CITY OF PORTLAND

July 16, 2003

RE: 75 York Street, application for minor site plan
ID #2003-0093, CBL #040C026

NOTE: SEE RETAINING WALL ELEVATION FOR CONTROL JOINT LOCATIONS
TYP RETAINING WALL CONTROL JOINT
1"=1'-0"

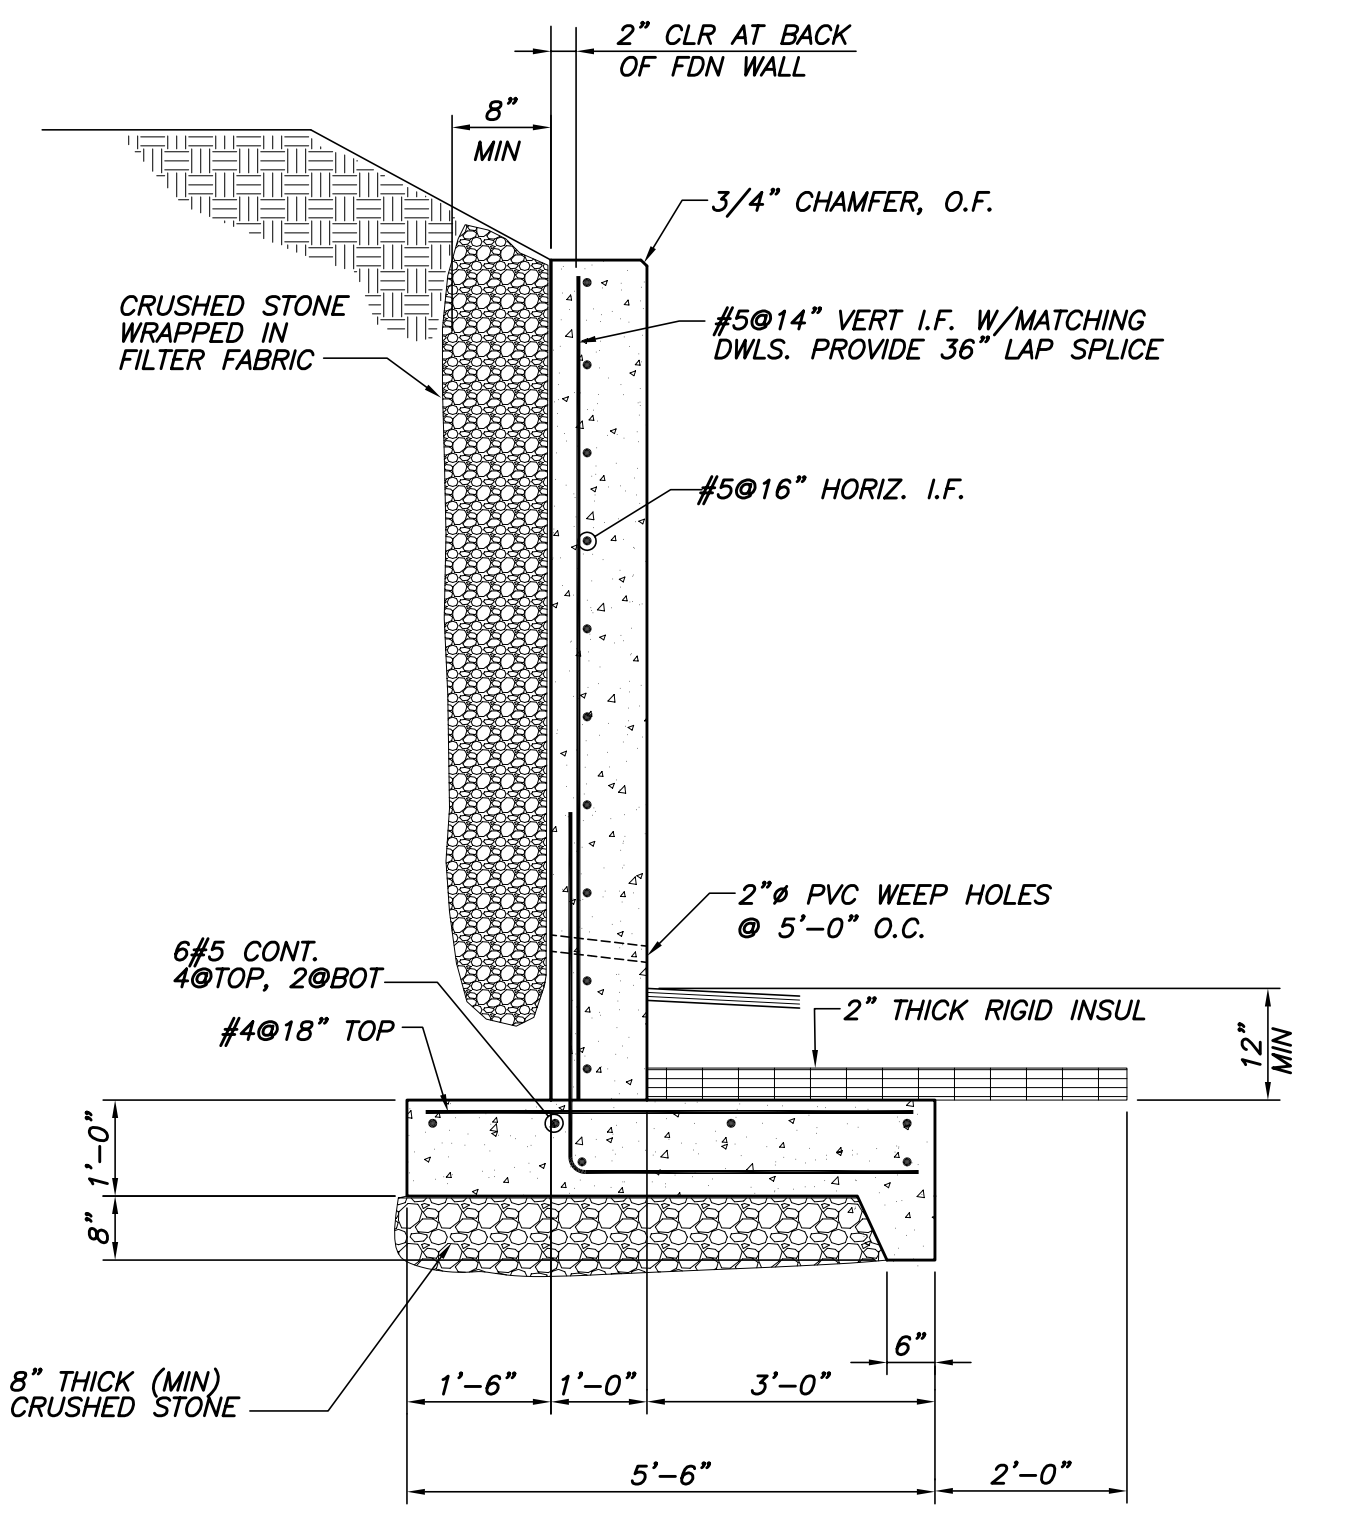
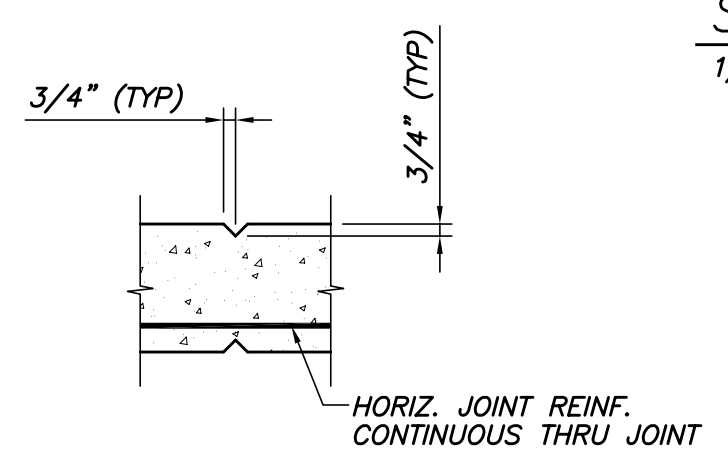
1. Retainer wall, which crosses over the westerly boundary line.
2. Drywell, which crosses over the easterly boundary line.
3. Removal of concrete steps over the northerly boundary line.
4. Removal of existing one-story addition over the northerly boundary line.

These items will need resolve prior to any more work occurring on site. The city will need to have a stamped licensed survey of the entire property to evaluate any future proposals or redesigns associated with this project.

SITE PLAN

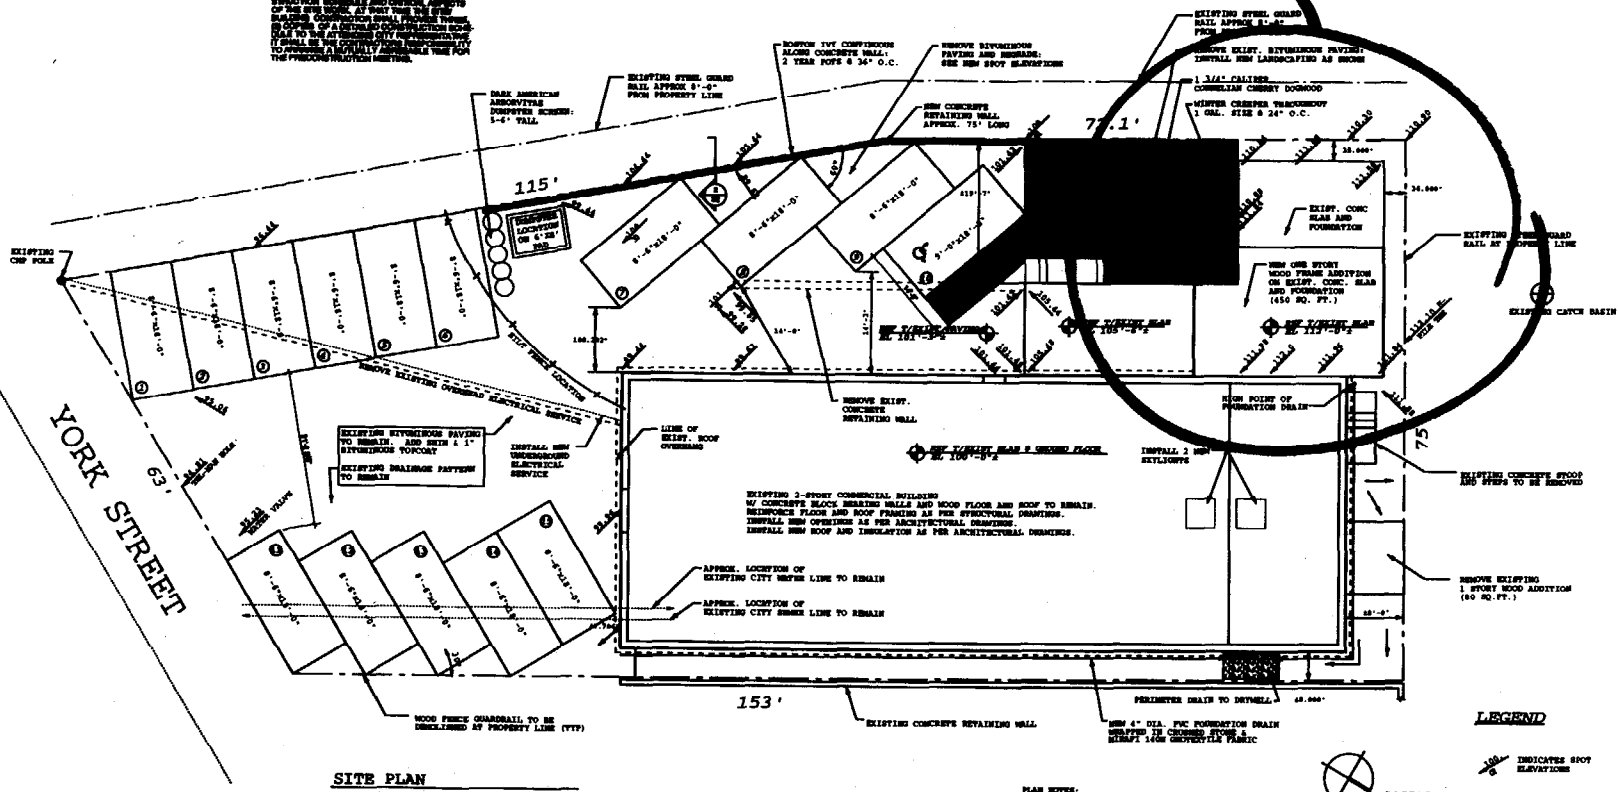
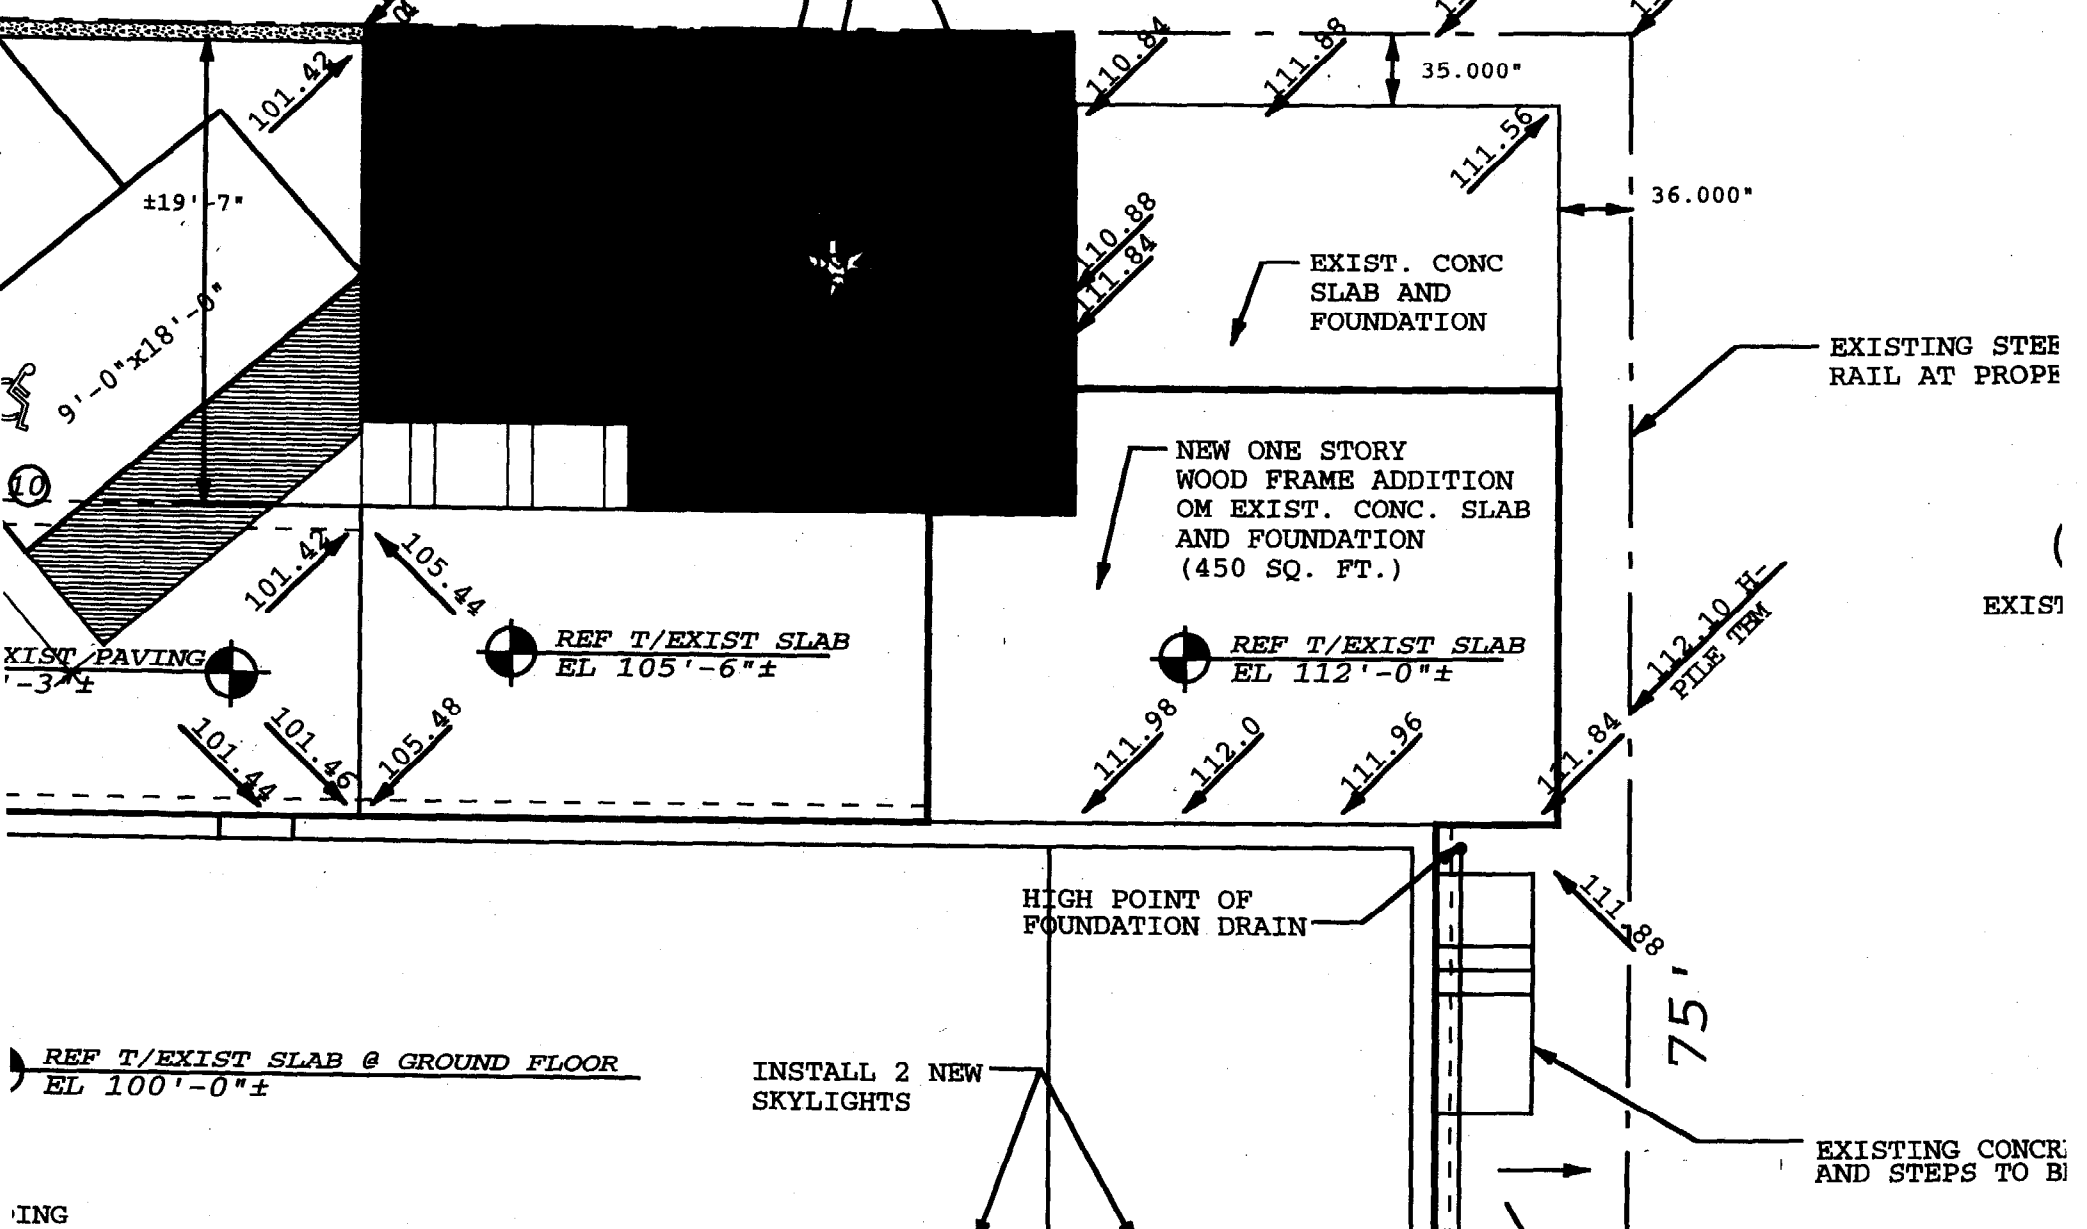
The site work that is affected by property encroachments is the following:

The City received a letter from an apparent abutter yesterday, which is in reference to the retainer wall and drywell. This letter does not correspond to the boundary lines on the site plan, nor does it allow proper right, title, and interest.
